**Application for a non-material amendment following a grant of planning permission.
Town and Country Planning Act 1990**

LOFT CONVERSION WITH TWO DORMERS, PLUS REPLACEMENT
CONSERVATORY ROOF.

EP/26/18/HH

Job Title	5 THE PLANTATION, EAST PRESTON			Item	PROPOSED EAST & WEST ELEVATIONS	
Designed by	Date	Checked by	Job No.	Sheet	FR. 05	Rev. A

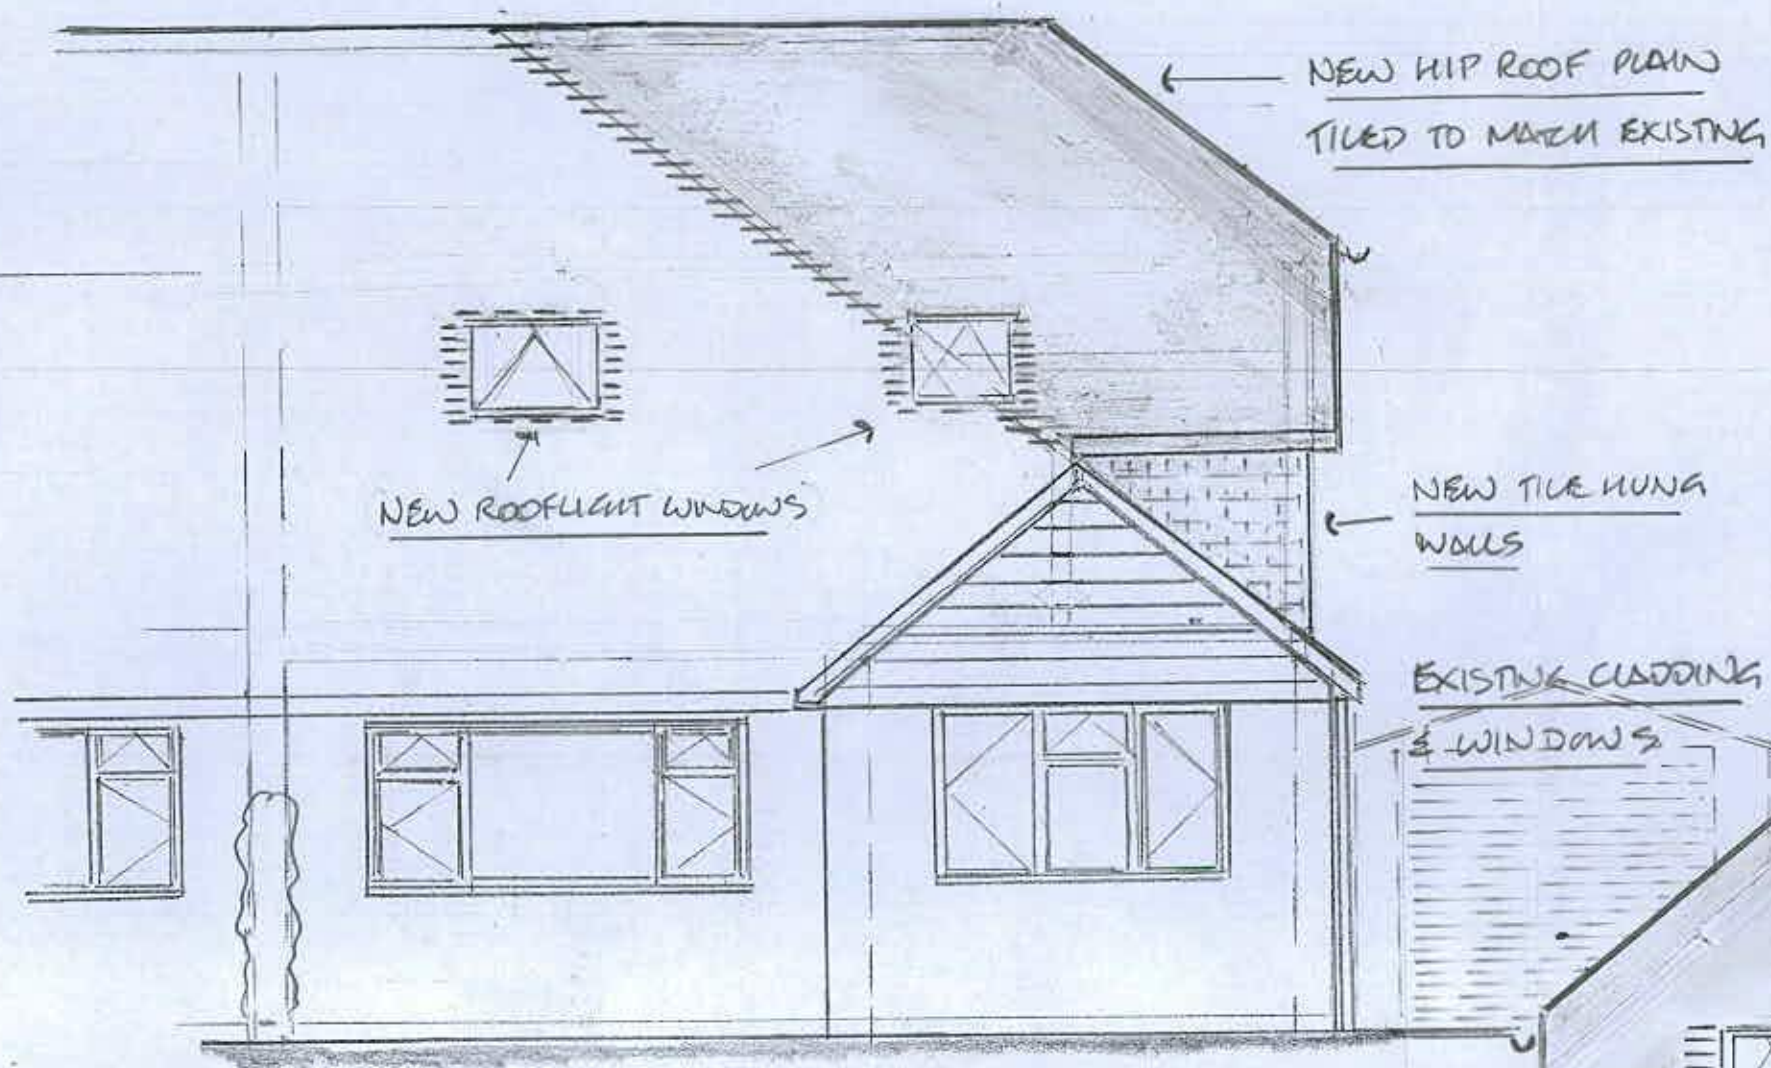
RIDGE LENGTH CORRECTED (ORIGINAL DRAFTING ERROR)

AN ORIGINAL DRAFTING ERROR HAS LED TO ONE PLAN SHOWING AN INCORRECT
LENGTH OF MAIN ROOF RIDGE LINE.
